Your Ref: Mr Craven
Our Ref: R/47/21/NMA

Non material amendment following the grant of R/210/20/HH for the addition of roof lights to the proposed extension & correction to existing floor plan.

Brambles Hurst Road East Preston BN16 3AP

Proposed
Extension
In Red

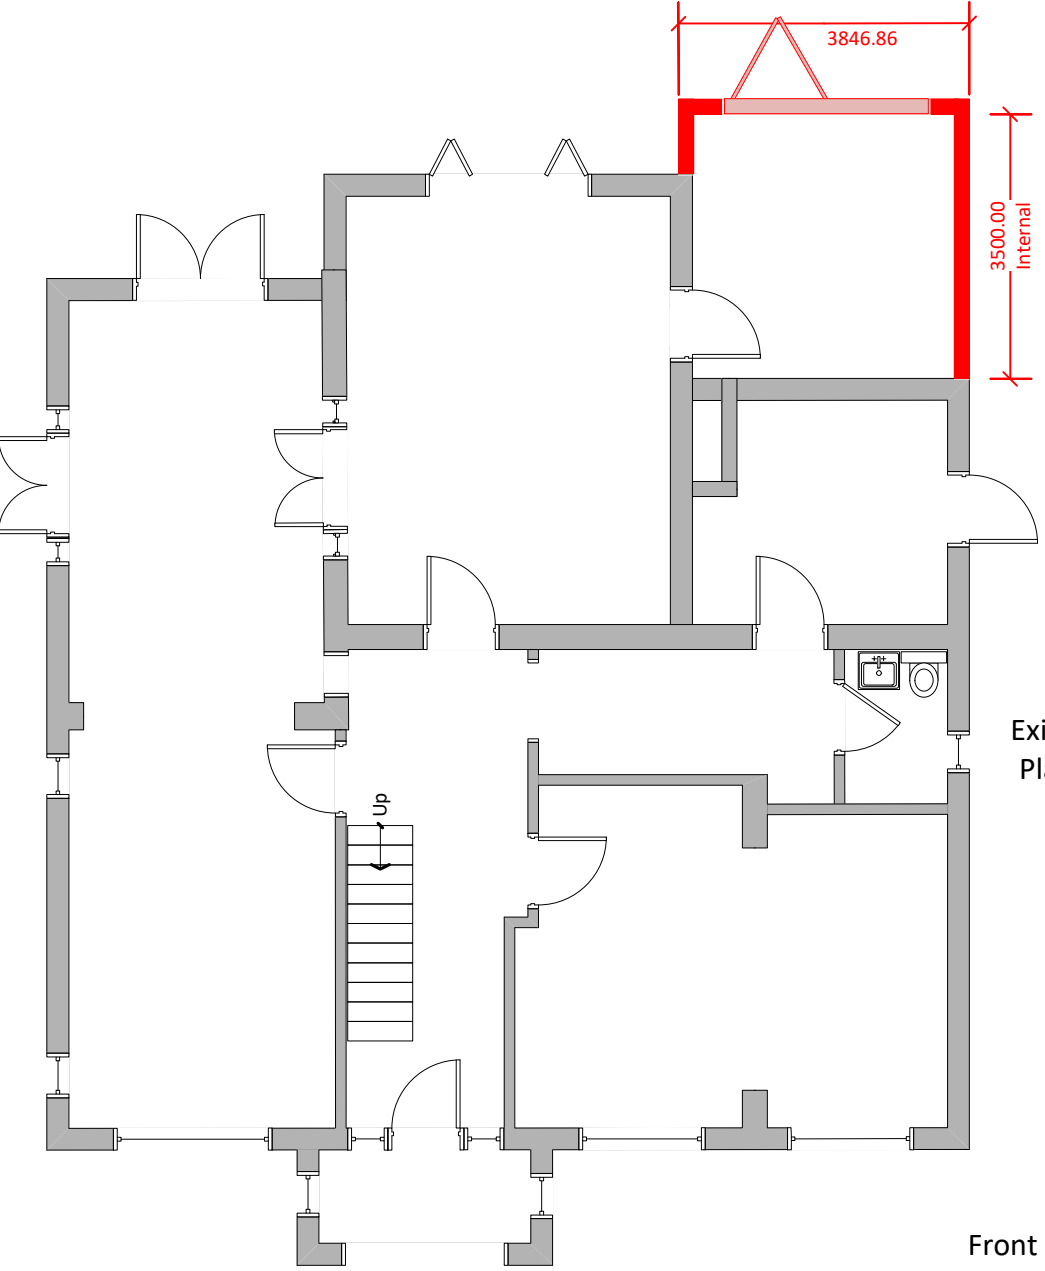
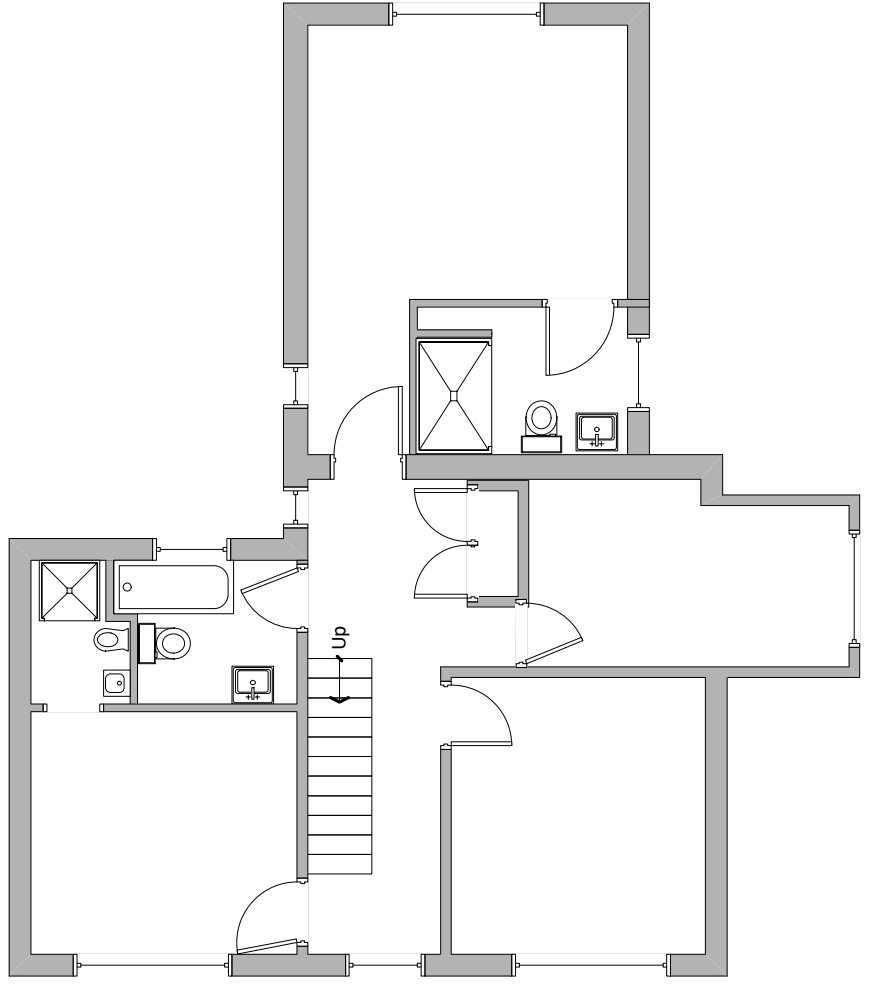
I refer to your recent application for a Non Material Minor Amendment. I note that you seek add roof lights to the proposed extension & correct the proposed floor plan to accord with the proposed elevation plan.

Please note that the originally approved proposed floor plans, proposed elevations and proposed roof plan are now replaced by the versions submitted in this application V2.
